Your ref: – Planning application, 2020 94307 1 Chadwick Crescent WF13 2JF.

We write with regards to the above planning application. We have studied the plans and know the site well. We strongly object to the proposed development.

**PROPOSED REAR ELEVATION**  
Scale 1:50@A1

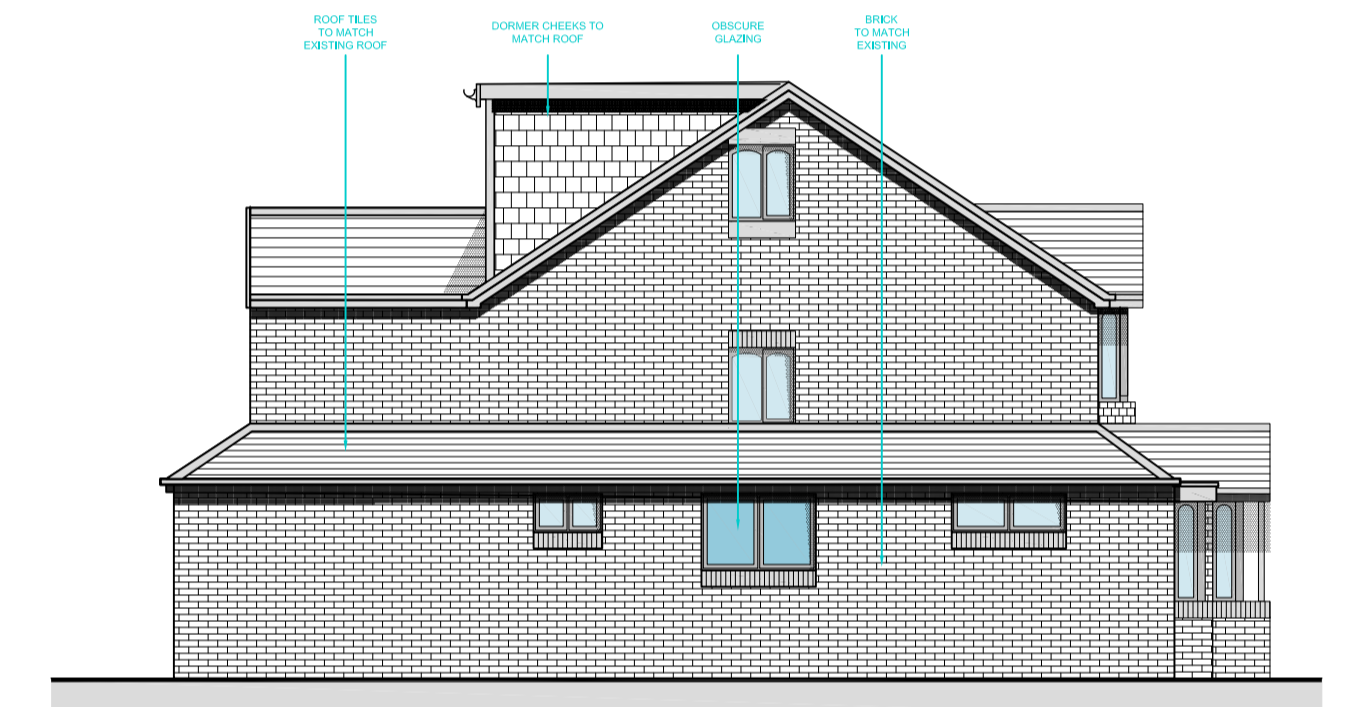
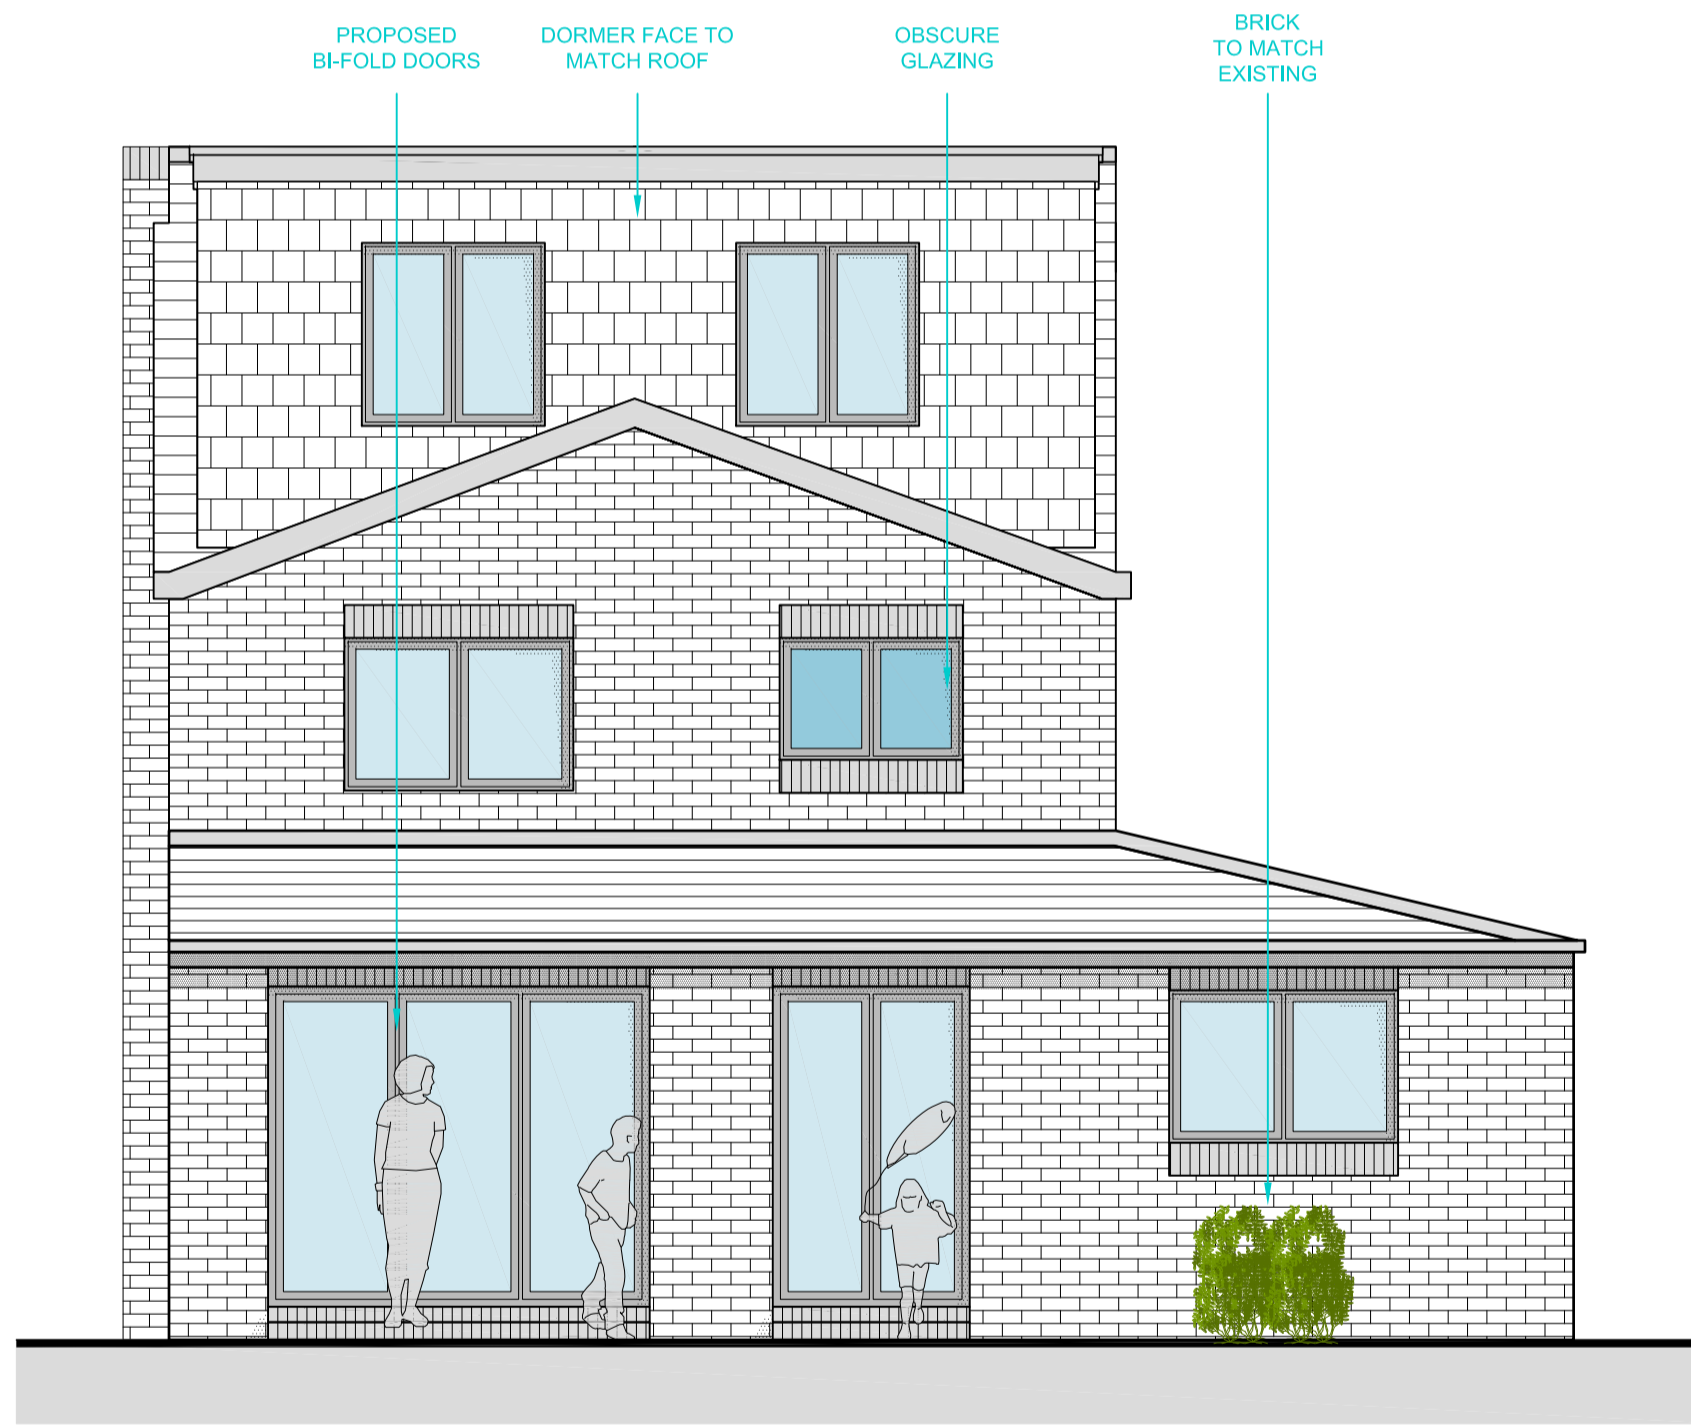
The proposed development by virtue of its scale, design and location with particular regard to the side and rear elevations, would result in an inappropriate type of development that is not in keeping with the surrounding area.

The height of the proposed elevations which is predominantly double storey are such that they will create over-bearing and over shadowing to neighbouring properties. Furthermore, we spend a significant amount of time sitting in our conservatory and thus fear the scale of the development will cause shadowing onto our property and thus reduce the amenity value we are currently afforded.

**PROPOSED SITE PLAN**  
Scale 1:500@A1

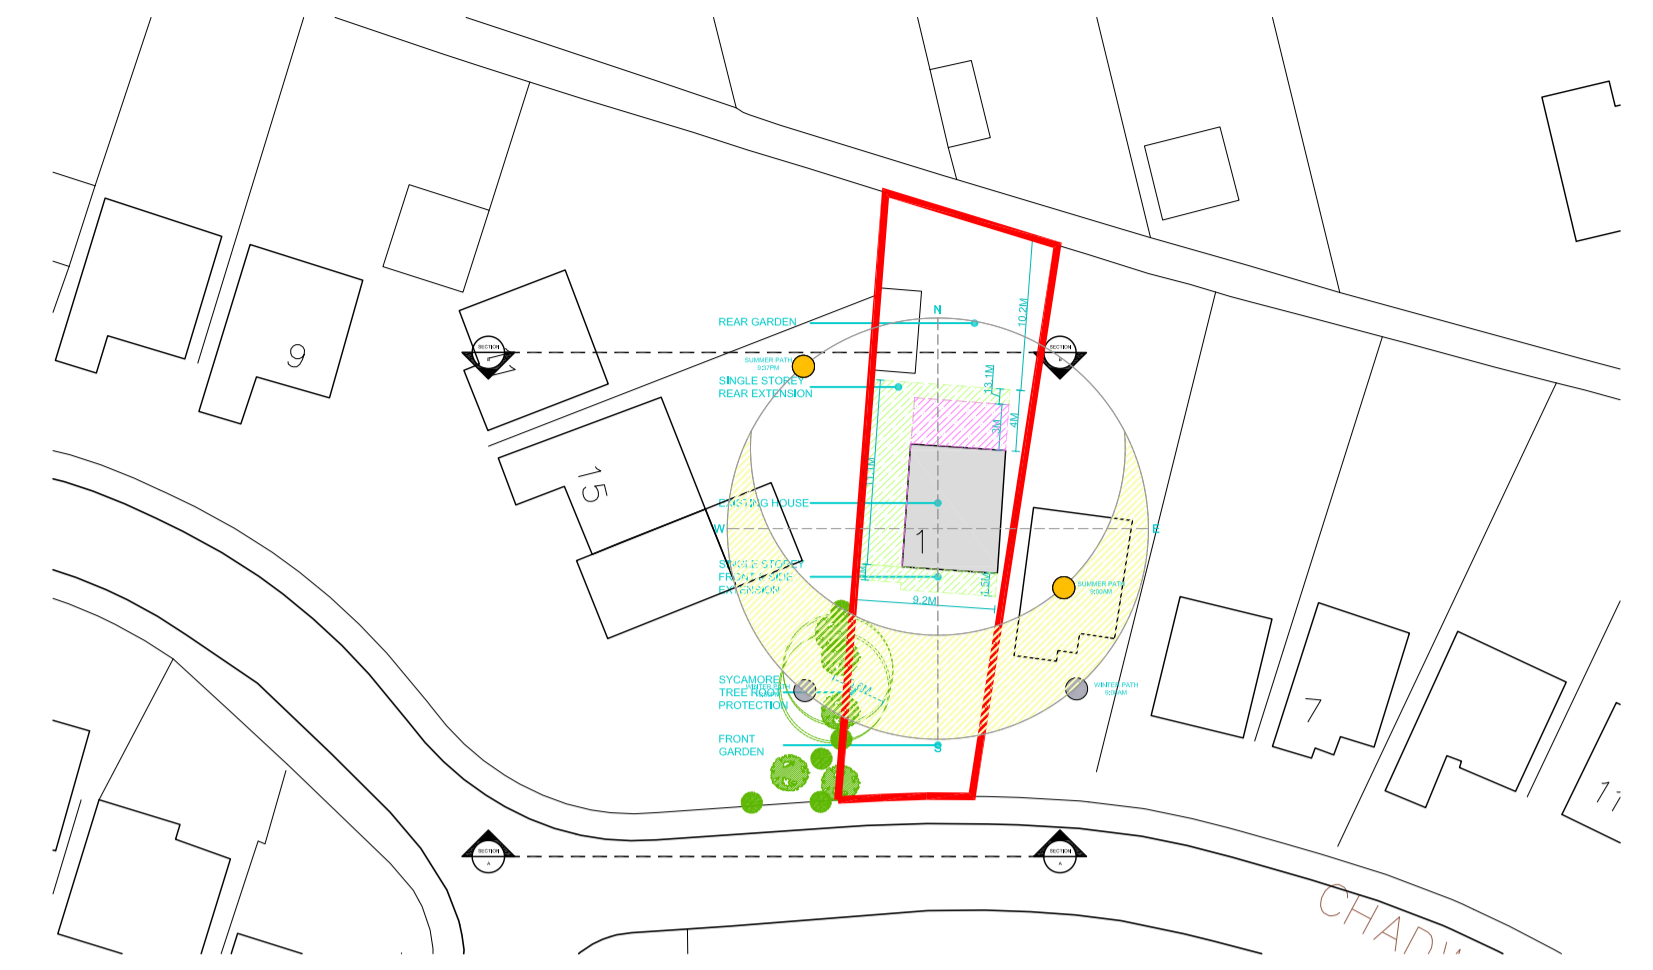
The size of the site (as shown on the plans) is not of a size which would be able to accommodate the sheer proposal of the build. To approve the plans as submitted would result in a clear overdevelopment of the plot and if this were granted it contravenes both the National Planning and Local Planning Policy Frameworks.

There is a large Sycamore Tree in the garden of 15 Infirmary Road which is the subject of a TPO. Both the Crown span and root area are also protected and if the proposal were approved, we are genuinely concerned for the future viability of the tree in both the short and long term. It would also place additional pressure to have the tree pruned or felled.
